## NSW RURAL FIRE SERVICE

Your reference: SSD-9143  
Our reference: DA-2019-03362

### Goulburn Poultry Processing Mixed Use Development – 52 Sinclair Street Goulburn

Project No - **W21314**
 Dwg No - **00K008 - 3**
 Date - **03/04/19**

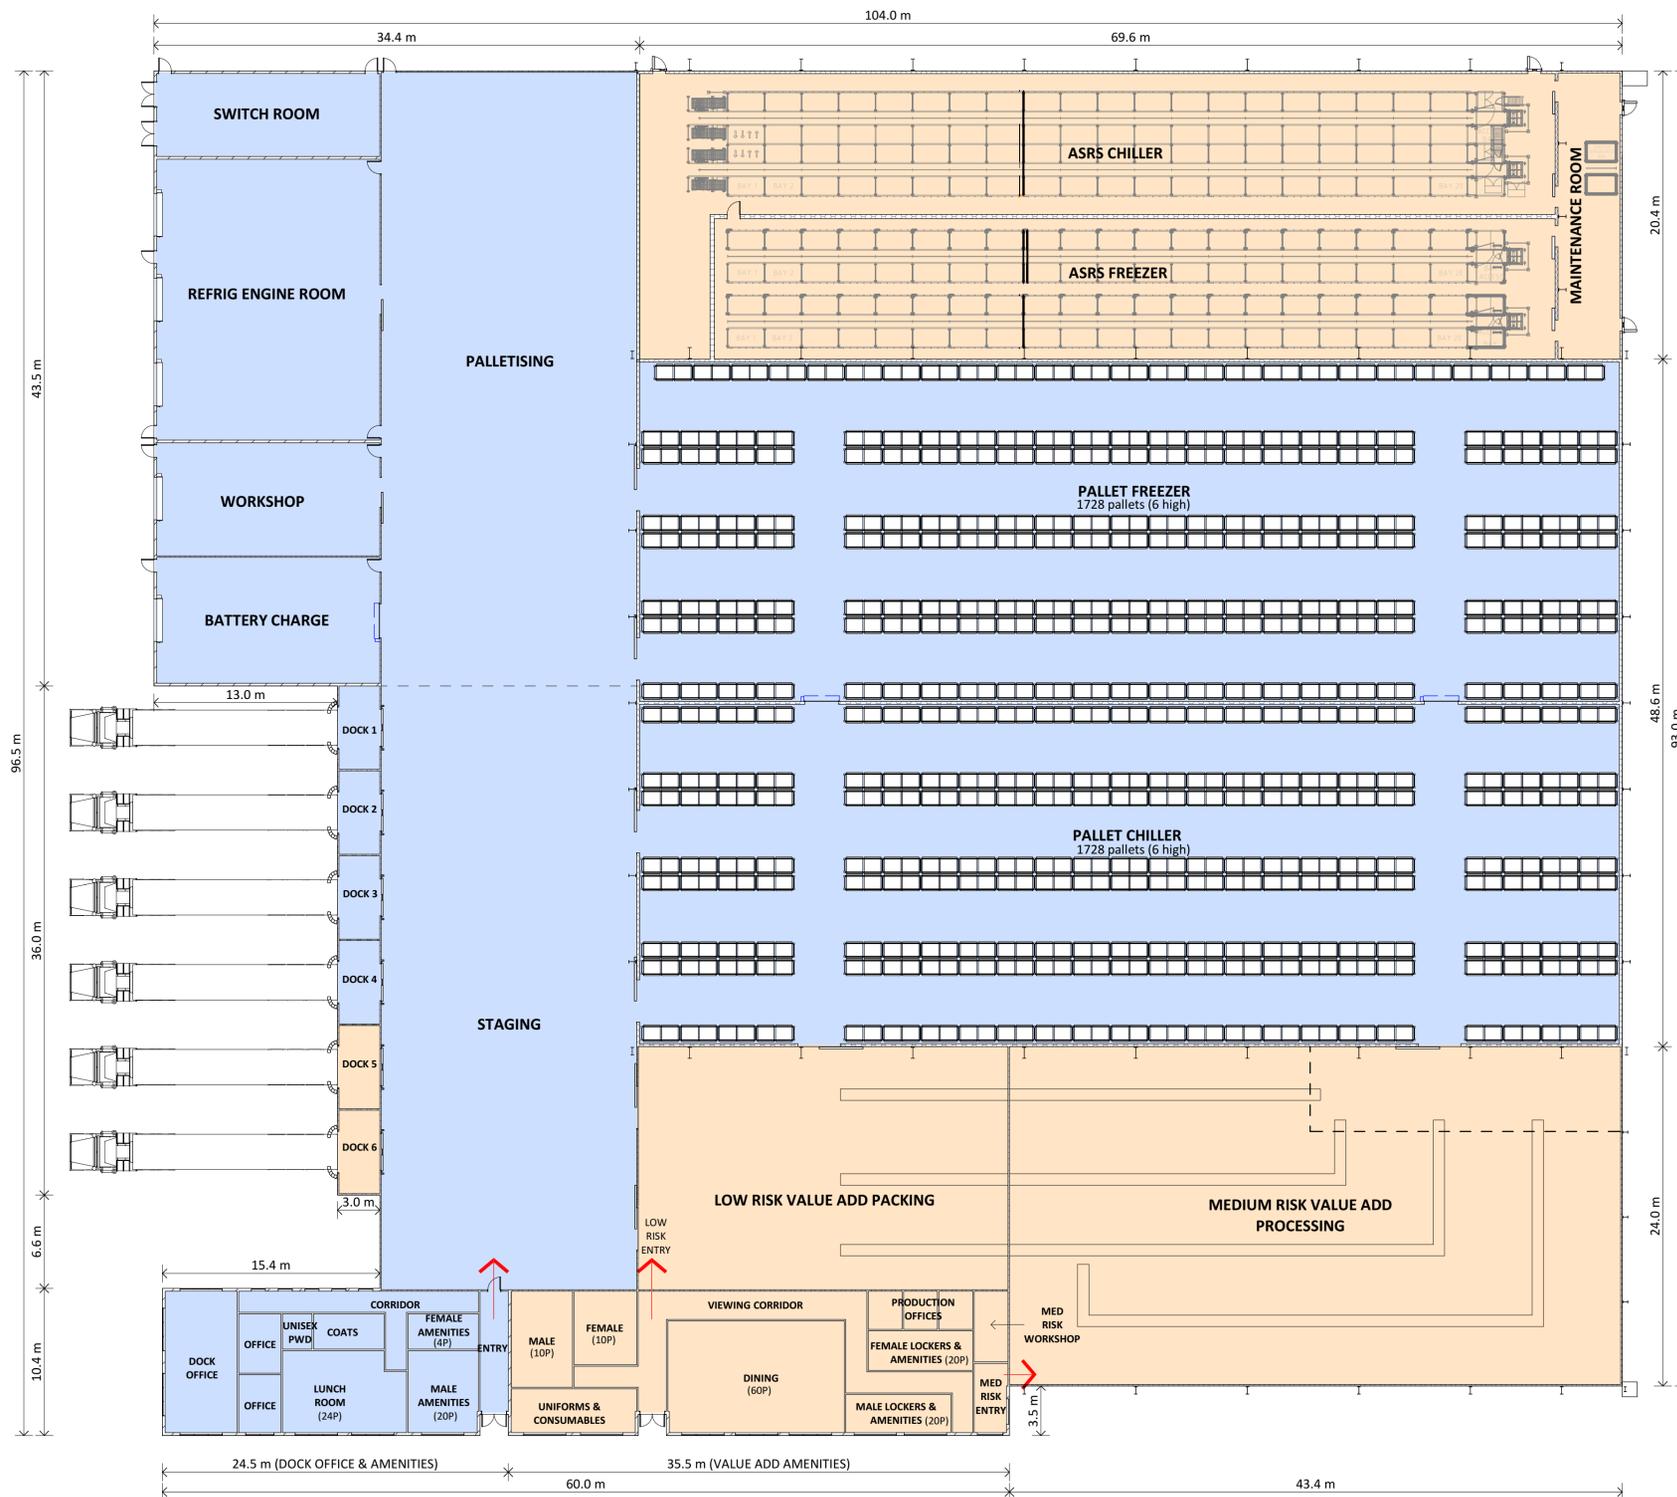
1. The development proposal is to generally comply with the overall site plan identified on the drawing prepared by Wiley and Co PTY LTD, numbered 00K008-3, dated 3rd April 2019.
